From: Samantha Legg <Samantha.Legg@lincolnshire.gov.uk>
Sent: 29 December 2025 12:14
To: _planningadvice
Subject: FAO - Sam Dewer re. H16-0692-25

Following the re-consultation for the above application and our interim comments.

Although they have largely addressed our previous concerns regarding the highway improvements, the comments below are to be addressed:

Appendix E
Traffic Flow Diagrams

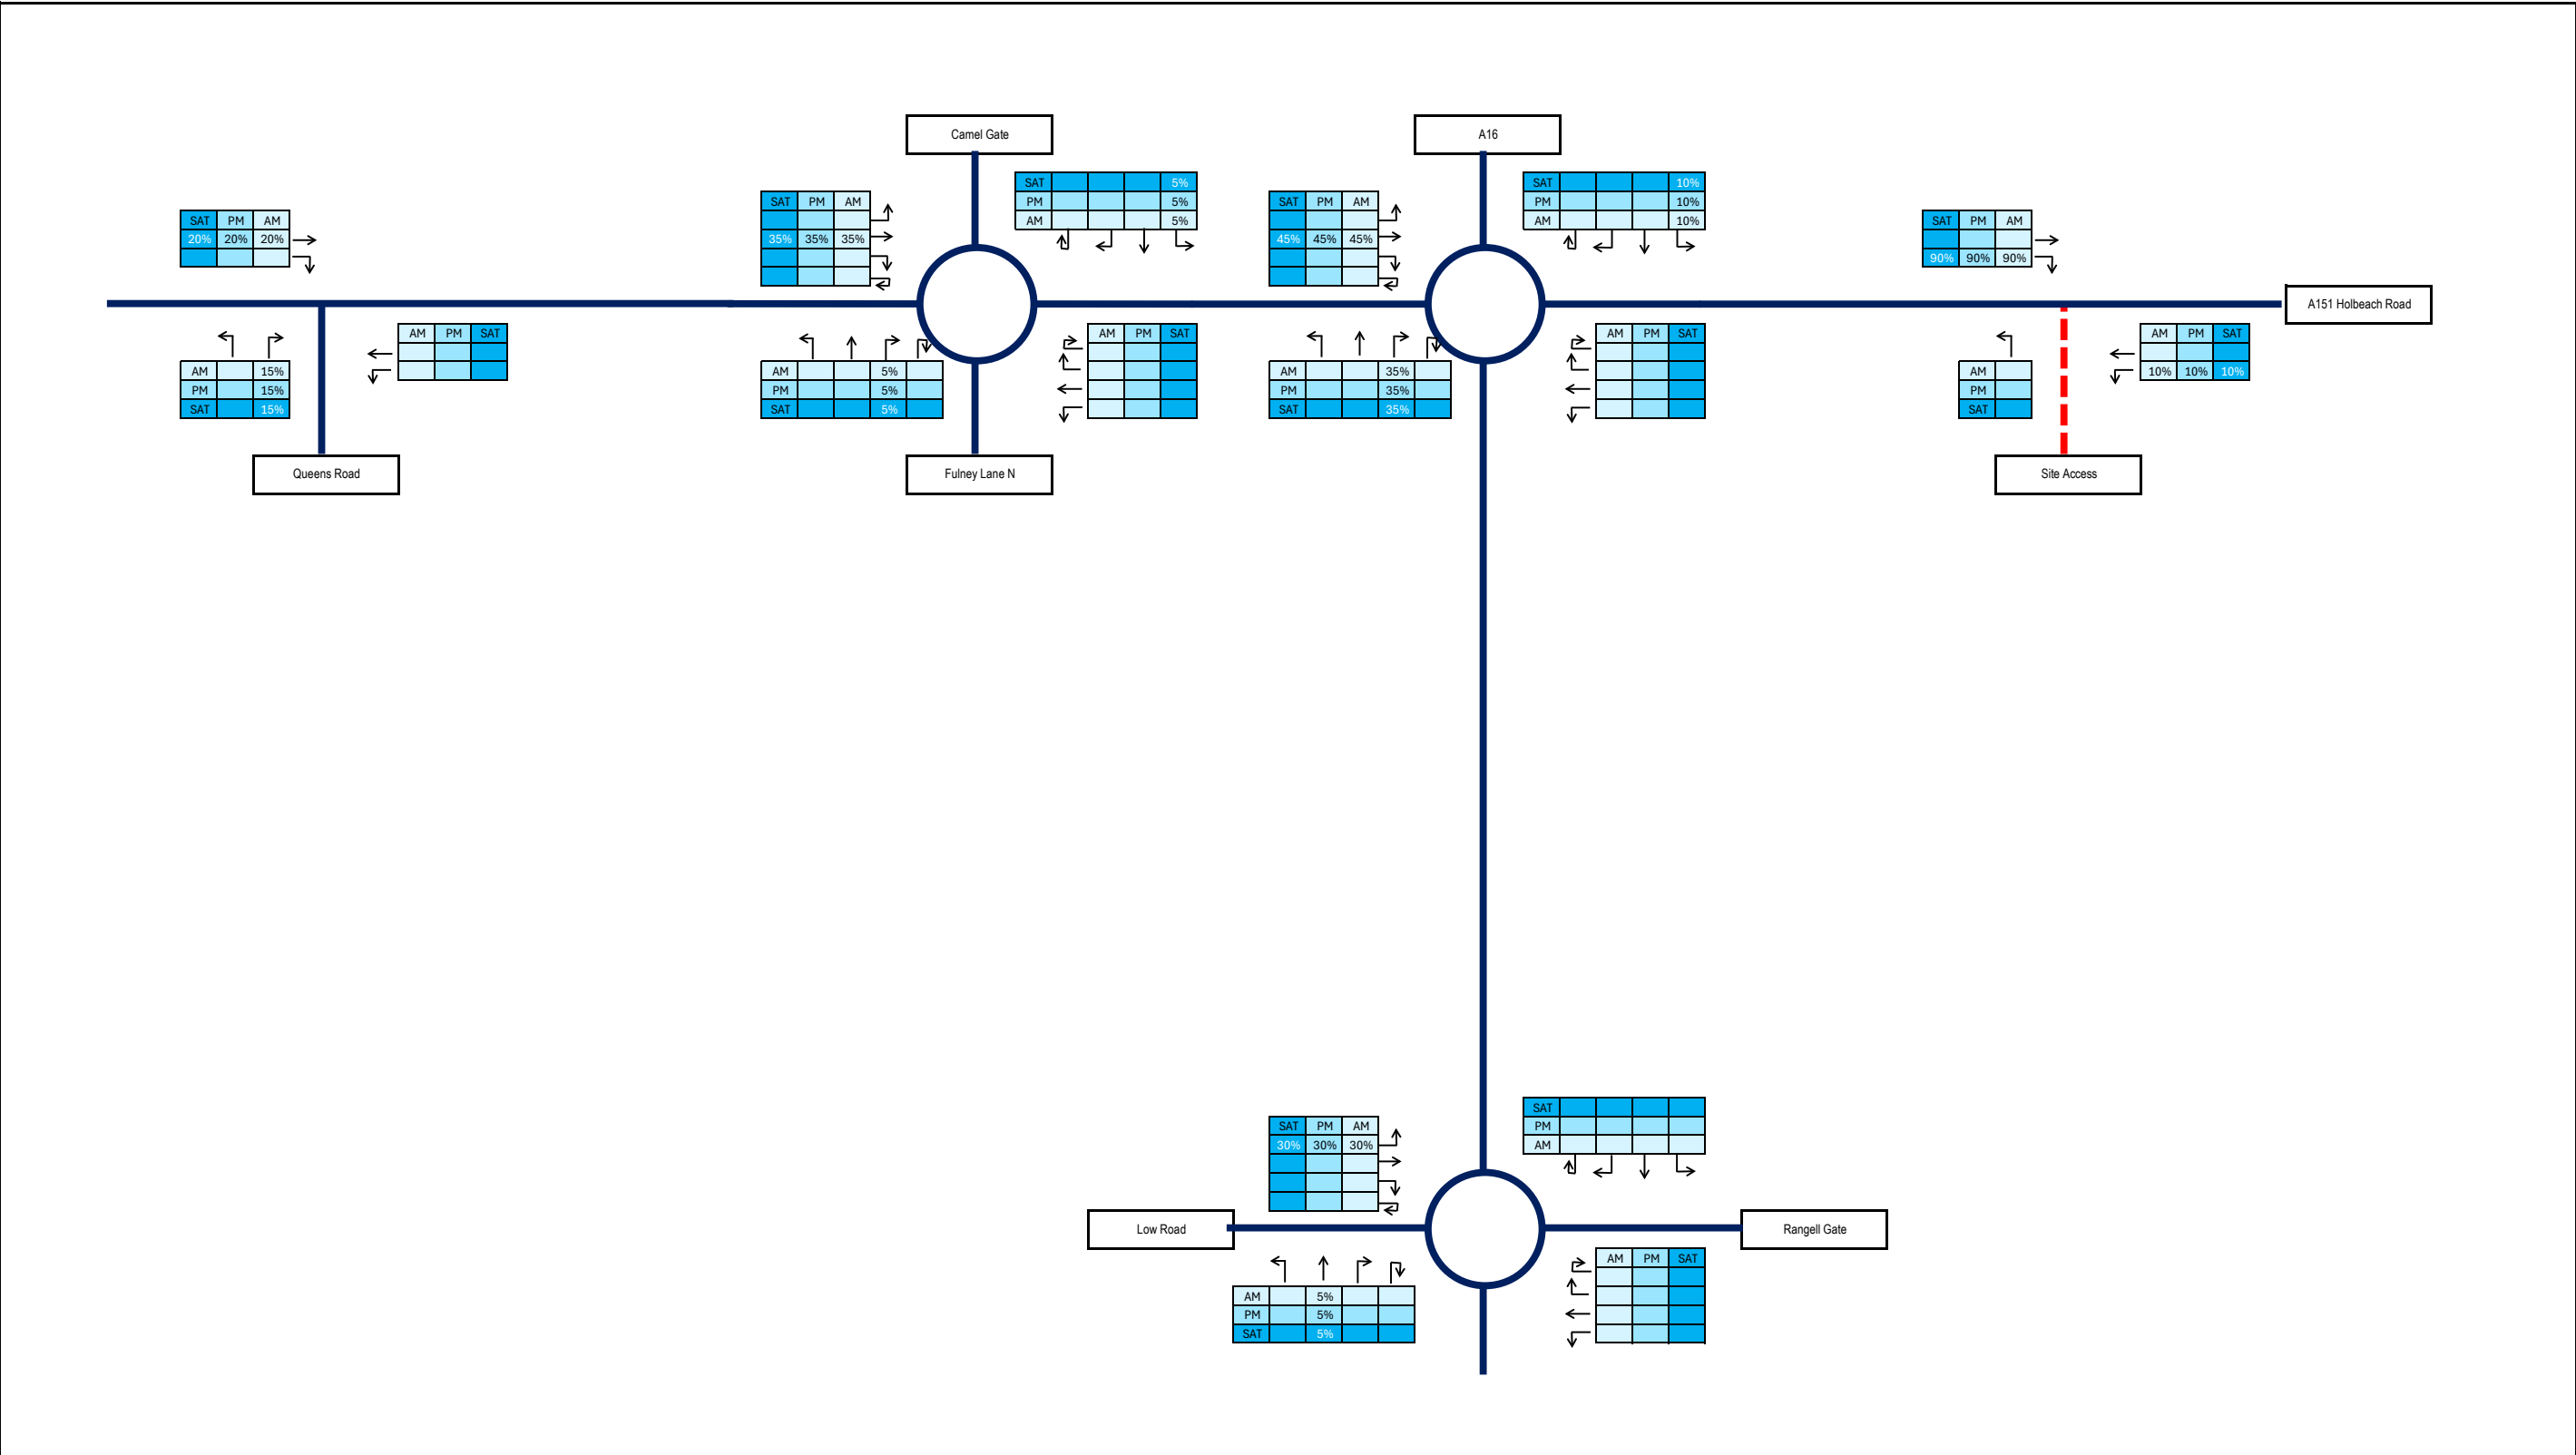
The Transport Assessment does not address safety and the accident data detailed is out of date. Concerns internally with queuing – particularly with it being a Drive Thru and how they operate. There should be a right turn lane internally to the Coffee Drive Thru so that queues internally do not back up into the highway. THIS HAS NOT BEEN ADDRESSED - If people are waiting to enter the Drive thru on the access road, then vehicles will not be able to access the foodstore hence why the drive thru needs its own right turn lane.

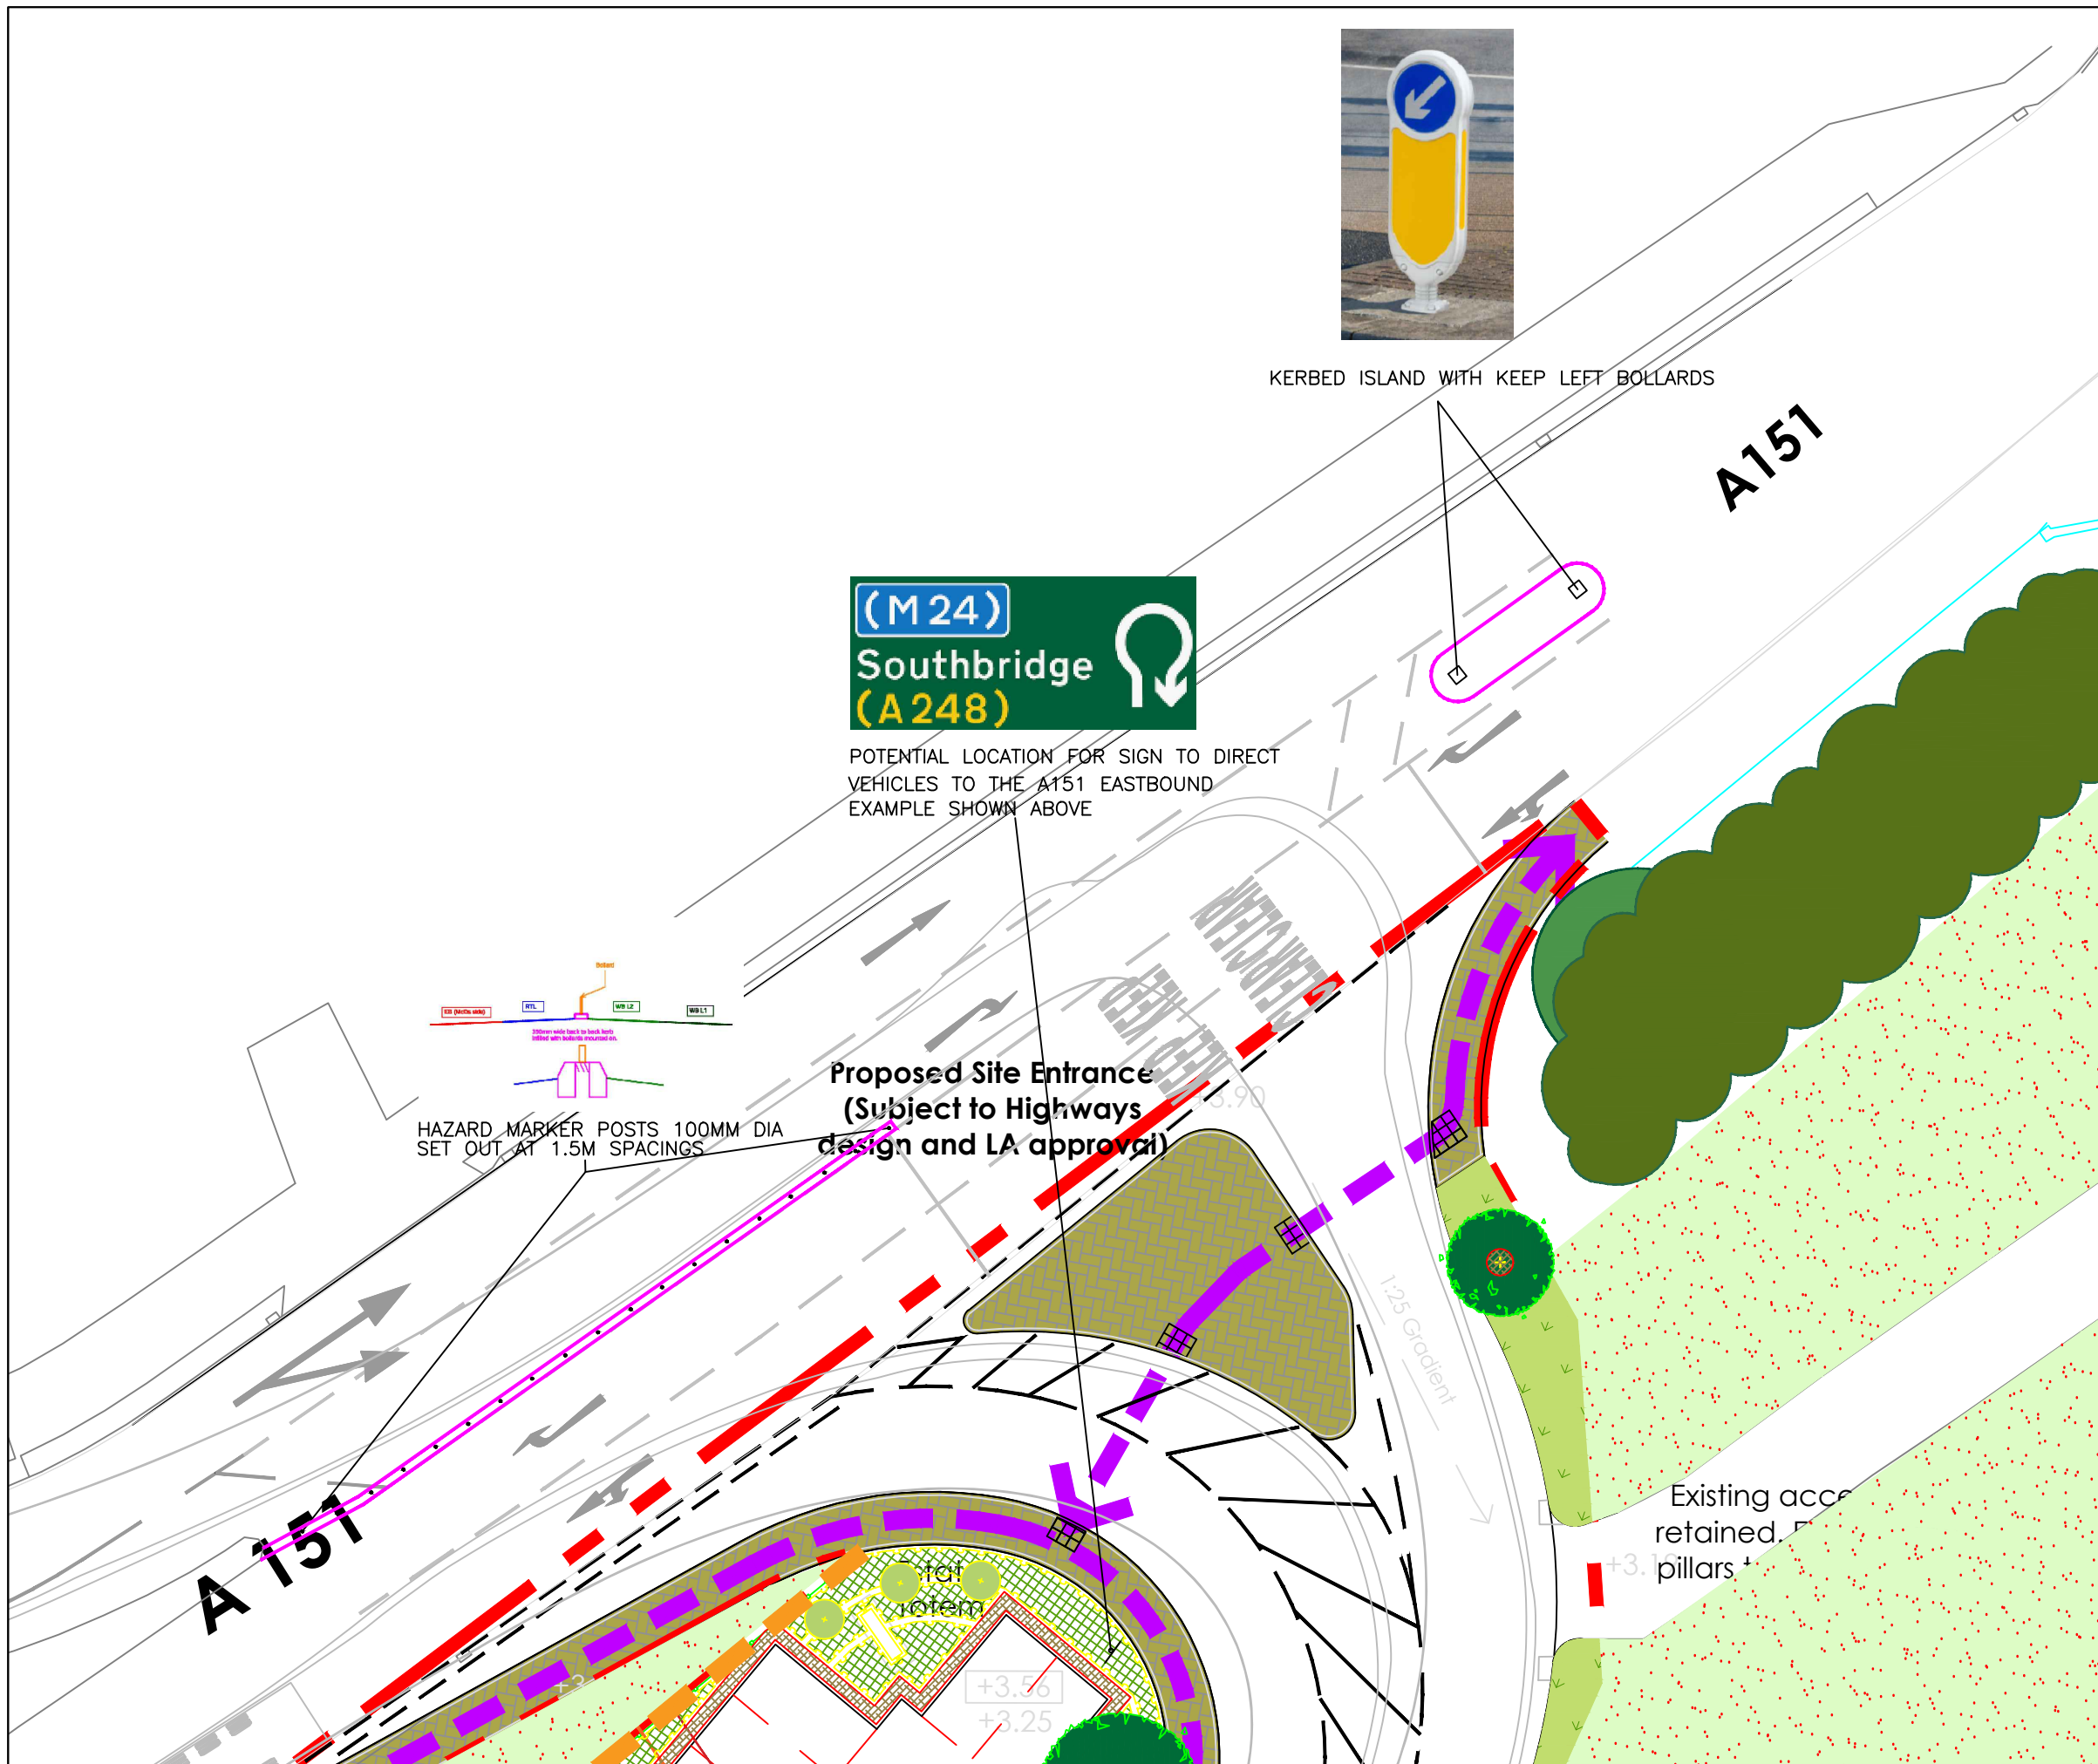
Right turns out of the development

- Although designed to deter such a movement, it would be beneficial to have 'No right turn' signage in the island on exit, backed up by a TRO. A Traffic regulation order will be done via a Section 106 Agreement. Approximate cost to be confirmed after the Christmas break.
